*Application for an Order granting Development Consent
for Botley West Solar Farm –(EN-010147)*

Botley West Solar Farm EN010147
Response by Stop Botley West (SBW)

Response to submissions of 16 July

Masterplan Changes Table - Post Examination

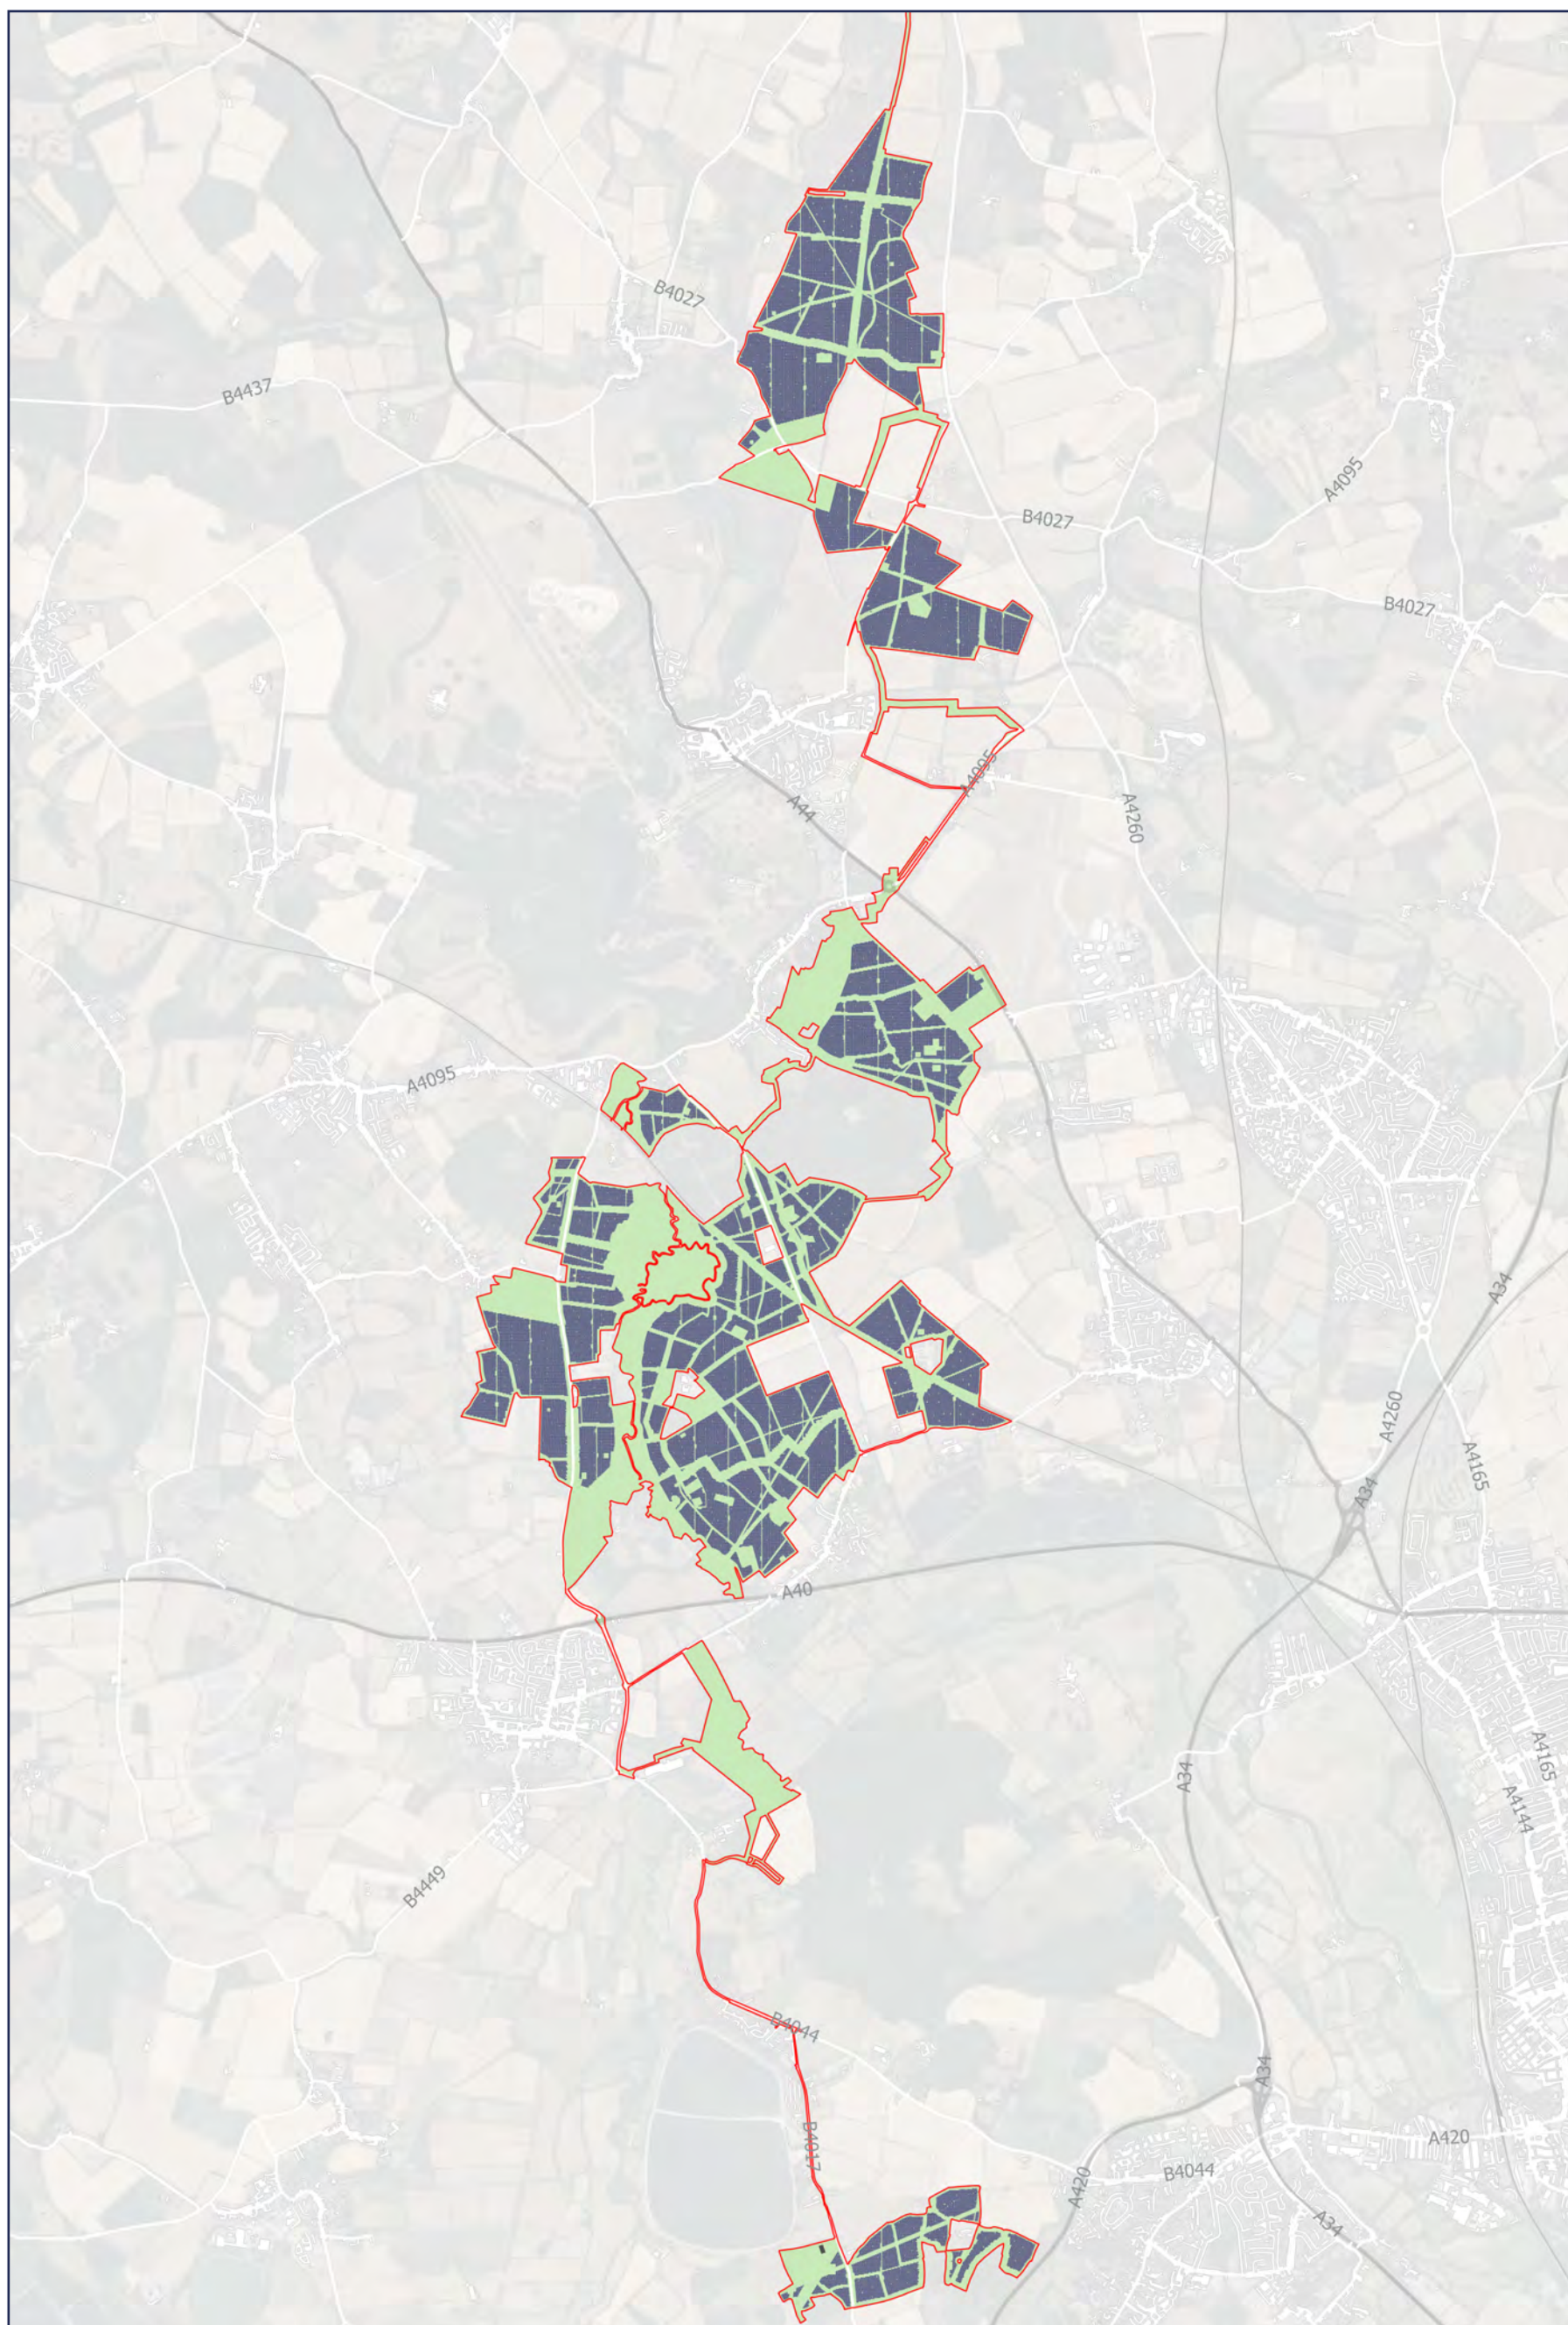
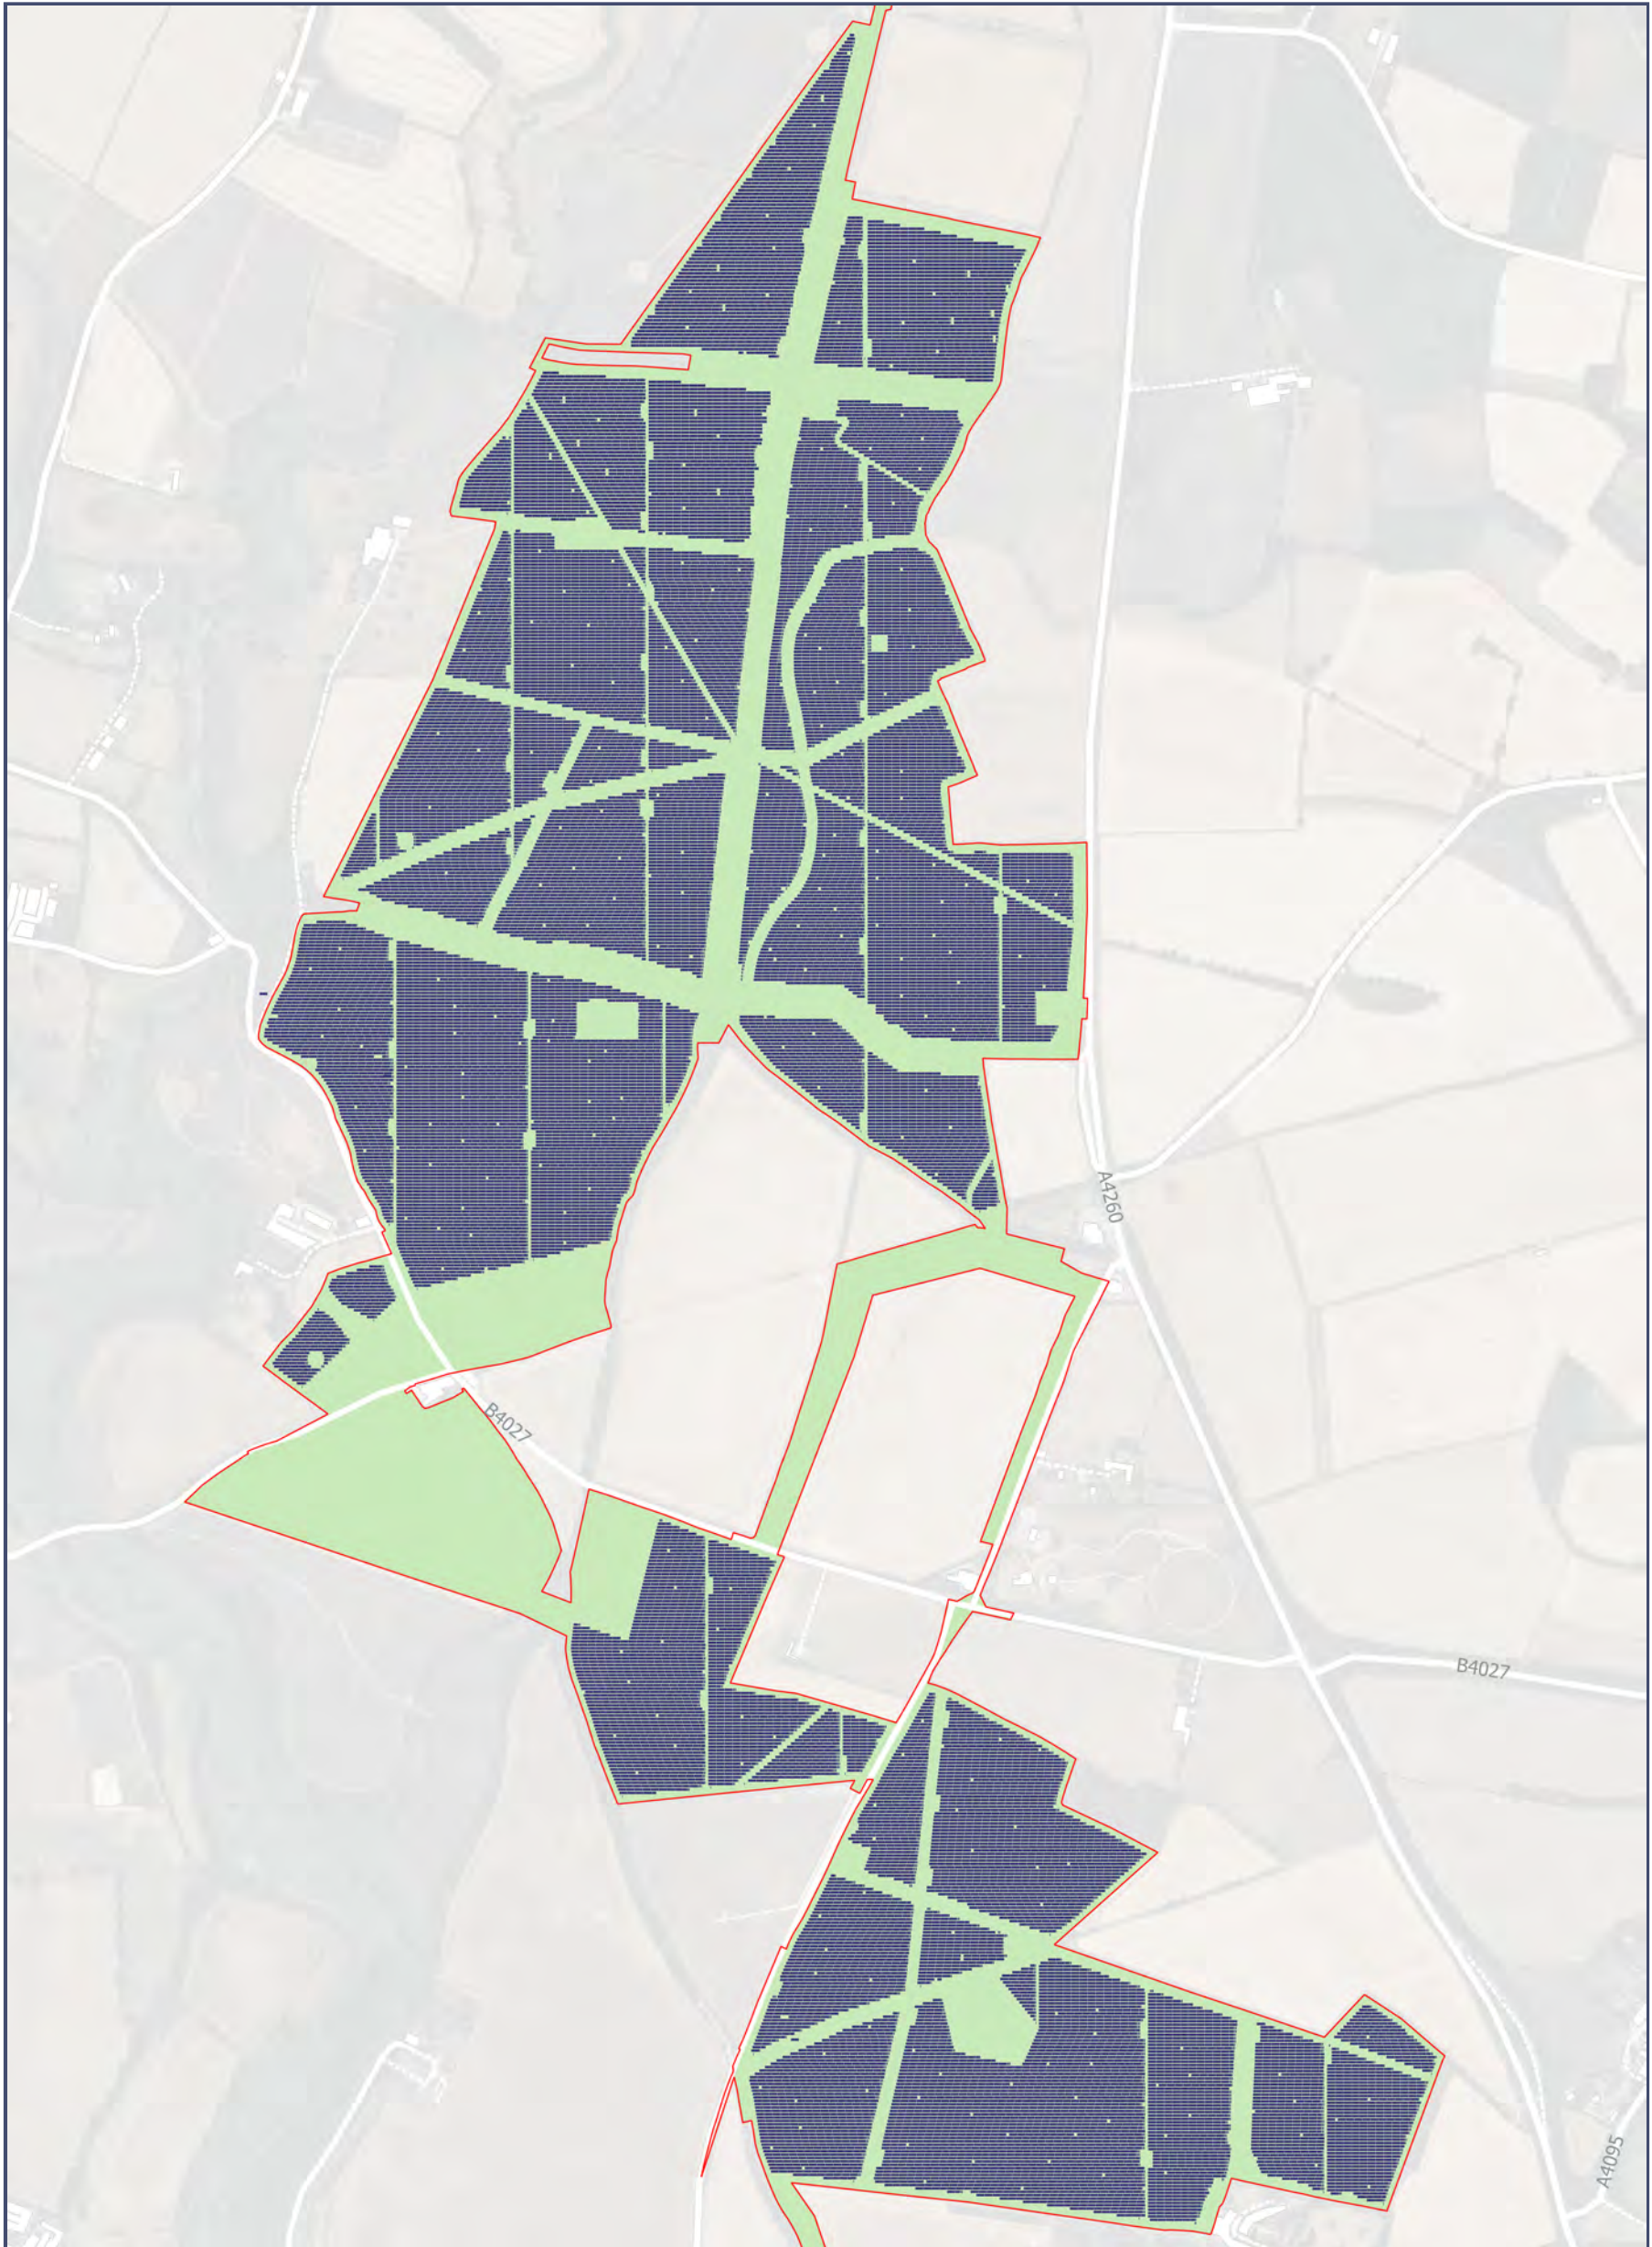
In the Applicant's latest (16 July) submission [C1-108, C1-109], its newly appointed consultants, Icen, have devised an "outline Residential Visual Amenity Plan" (oRVAP) Ref [C1-108] offering 100m as standard "with additional offsets up to 250m applied where needed". No criteria have been provided to explain how this "need" would be assessed post consent when it will be beyond public scrutiny.

Through this mechanism the Applicant has effectively changed the likely buffer for most properties to the minimum 100m instead of the buffer of 250m recommended by ExA and shown in the 9 June submission. By describing this change as an "improvement" comparing the new Masterplan (rev 5) with Masterplan rev3 of 11 Nov 2023 rather than with Masterplan rev4 of 9 June 2026, the Applicant has disguised the fact that the latest proposal is actually a regression.

June 9	July 16
Masterplan revision 4 [C1-051]	Masterplan revision 5 [C1-118]
Buffer of 250m shown	Buffer of 100m shown
New requirement 15 in Schedule 2 of dDCO describes a post consent RVAP (newly proposed on 9 June and not formally examined by ExA) which must set out justification for the distance proposed between 100m and 250m and must be approved by the local planning authority.	Amended requirement 15 in Schedule 2 of dDCO says: <i>"The RVAP must be substantially in accordance with the outline RVAP"</i> . Note: this oRVAP [newly proposed on 16 July] has not been formally examined by ExA nor approved by the local planning authority.
In response to the SoS request for information (letter 20/4/2026), the Applicant offered to increase the buffer distances from sensitive receptors [to 250m], as illustrated in the updated Masterplan Rev 4, stating: <i>"It is judged that these updates would result in beneficial effects for a number of individual residential receptors and settlement areas including, but not limited to, the residential visual amenity of Dornford Cottage, properties at Shipton Slade Farm, properties in Bladon, Burleigh House, College Farm and Church Hanborough"</i> .	Masterplan Rev 5. [C1-020] is informed by the new RVAA which repeats the previous errors in assessing whether vegetation already screens the property and consequently underestimates the impact on residential visual amenity for properties such as Dornford Cottage, Shipton Slade, College Farm, Goose Eye Farm and others. The effect of reducing the buffer to 100m would be to reverse the "beneficial effects" described on 9 June.

There is no justification for the most recent reduction of buffer size from 250m to 100m for most properties. Indeed, in its answer [C1-087] to question 27 of SoS 14 April letter, the Applicant admitted that that the project would still be viable, albeit marginally, with 250m buffers for all.

Masterplan revision 5 [C1-118] submitted on 16 July conversely shows buffers of **100m**.
